GG119 ROAD SAFETY AUDIT RESPONSE REPORT

Project Title:	Section 278 Access Works – Field Head Lane, Birstall
Project Team:	DART Engineers Ltd
RSA Report Stage	Stage 1 & 2
RSA Organisation:	Via Solutions Ltd
RSA Report Reference:	26019 Field Head Lane Stage 1 & 2 RSA Issue 01
RSA Report Issue Date:	March 2026
Report Title:	GG119 Road Safety Audit Response Report
Reference:	26019-RSA-RR-01

This report relates to a Stage 1 & 2 Road Safety Audit for S278 works at Field Head Lane, Birstall, comprising a priority junction access and associated highway works.

No.	Revision	Date	Drwn
Status			
Client STONEWATER			
Project FIELD HEAD LANE BIRSTALL			
Drawing title S278 VEHICLE SWEEP PATH TRACKING			
Drawn RT	Chkd AD	Date SEPT 25	Scale 1:100
Contract No. 25469	Drw No. DR-C-0136-2	Revision	P2

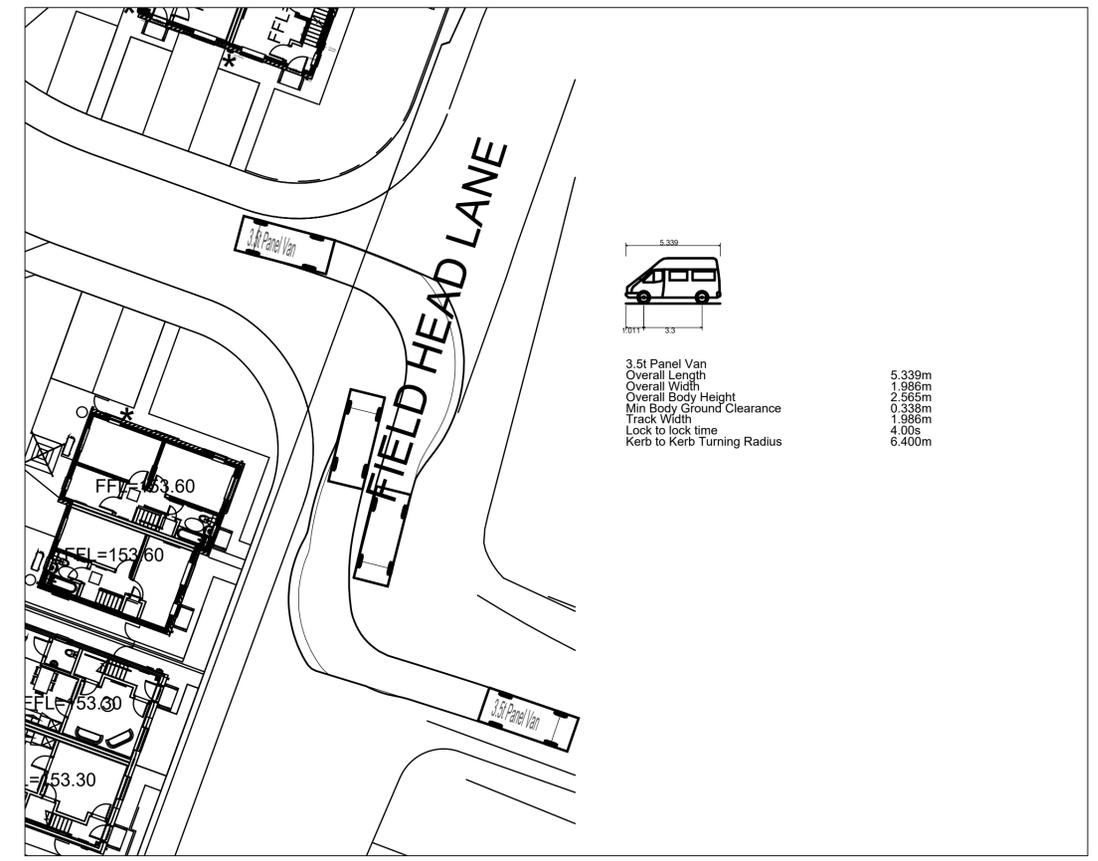
Summary: It is not clear if the tracking analysis demonstrates that there is sufficient carriageway available at the junction.

Detail: It is not clear if there will be sufficient carriageway available to accommodate vehicle turning movements at the junction, particularly for large vehicles, if vehicles are parked directly opposite the junction on the east side of Field Head Lane. This will result in vehicles riding onto the footpaths and at risk of conflicting with pedestrians.

Recommendation It is recommended that the designers ensure that there is sufficient carriageway and or waiting restrictions (yellow lines) provided at the junction to the site, to accommodate all vehicle turning movements on and off Field Head Lane, particularly when vehicles are parked on the east side of Field Head Lane.

Design Team Swept path analysis has been undertaken (Drawing 25469-DR-C-0136 Rev P2) which demonstrates that the design vehicles can successfully enter and exit the junction without overrunning the footways under typical (unobstructed) conditions .

The scenario identified within the RSA, namely the presence of parked vehicles on the east side of Field Head Lane opposite the junction, has been reviewed qualitatively. It is acknowledged that in such circumstances the effective carriageway width would be locally reduced.

The junction geometry has been designed to accommodate the design vehicle within the available carriageway, and even in the presence of parked vehicles, turning movements would remain achievable, albeit with reduced margins. The likelihood of vehicles mounting the footway is considered low given the low-speed environment, good forward visibility and driver awareness.

On this basis, the arrangement is considered to operate safely and in line with standard residential highway conditions. The introduction of waiting restrictions is not considered necessary to achieve a safe and functional access, although this remains a matter for the Highway Authority should they wish to control parking locally.
